From: Mark Warwick
Sent: 19 September 2018 13:25
To: Amber Willard
Cc: Planning.Responses
Subject: Prior Notification Of Works To Tree(s) In A Conservation Area - FP/190/18/TC

Application ref: FP/190/18/TC

Location: Land between 3 and 9 Old Rectory Gardens, Felpham

Works proposed: 1.5m Crown Reduction of 1No. Willow & 1No. Bay within Felpham conservation area.

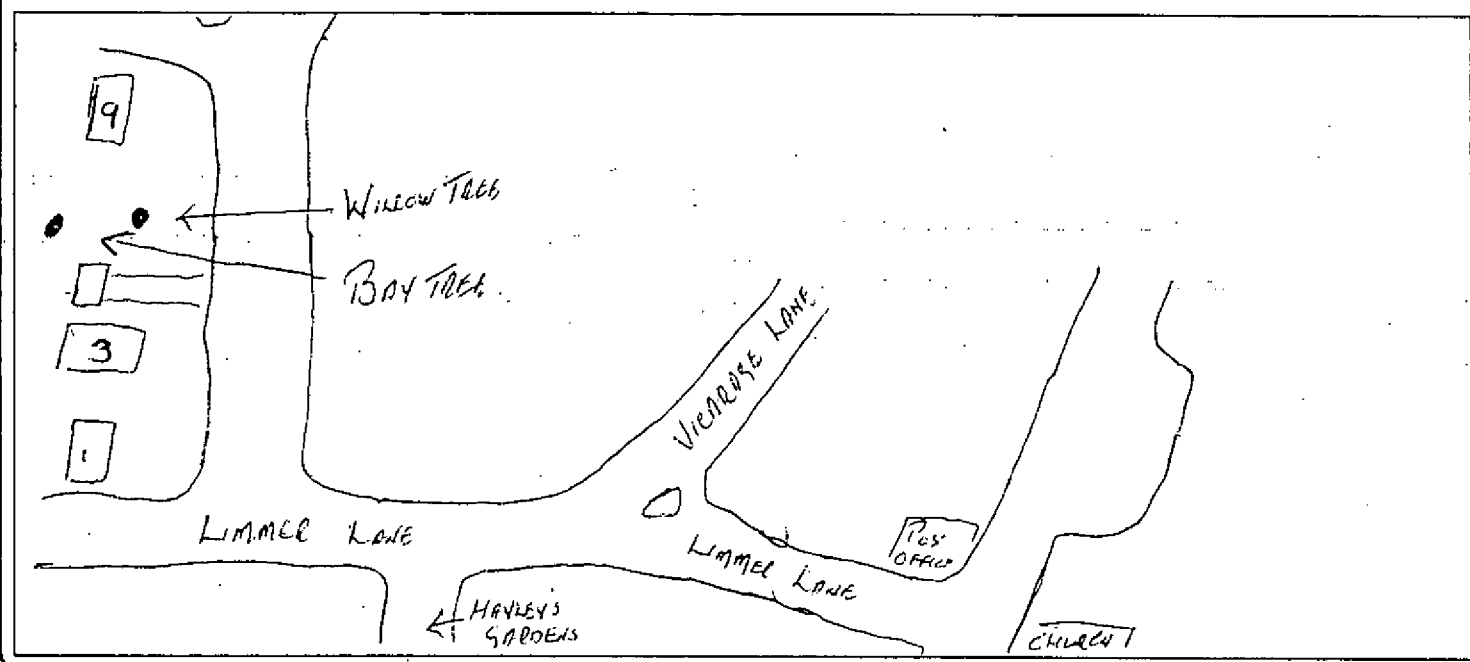
The willow tree is correctly identified and plotted reasonably accurately on the plan. I am able to make a determination on this element of the application although I would advise the applicant subsequently considers stating an intention to remove low growth above the adjacent road to a minimum height of 5metres and back to the kerbline, in a new application. On completion, that work would meet their obligation to ensure unobstructed access along the public highway for high-sided vehicles.

The only bay tree (*Laurus nobilis*) in the immediate locality is a small specimen of no more than 5metres height, growing approximately 8metres due southeast of the aforementioned willow and adjacent a boundary fence. It grows from within the rear garden of 24 Limmer Lane. This is a considerable distance from the position marked on the applicant's plan. The mark would seem to correspond with the position of a mature silver birch tree.

The information provided in relation to the bay tree does not correspond with my observations on site, so I am unable to determine this element of the application.

I suggest the applicant re-submits an application following advice from a Tree Specialist who will be able to correctly identify and accurately plot on a map all trees intended for work. This must be supported by an appropriate and comprehensive work specification, to enable us to make an informed decision.
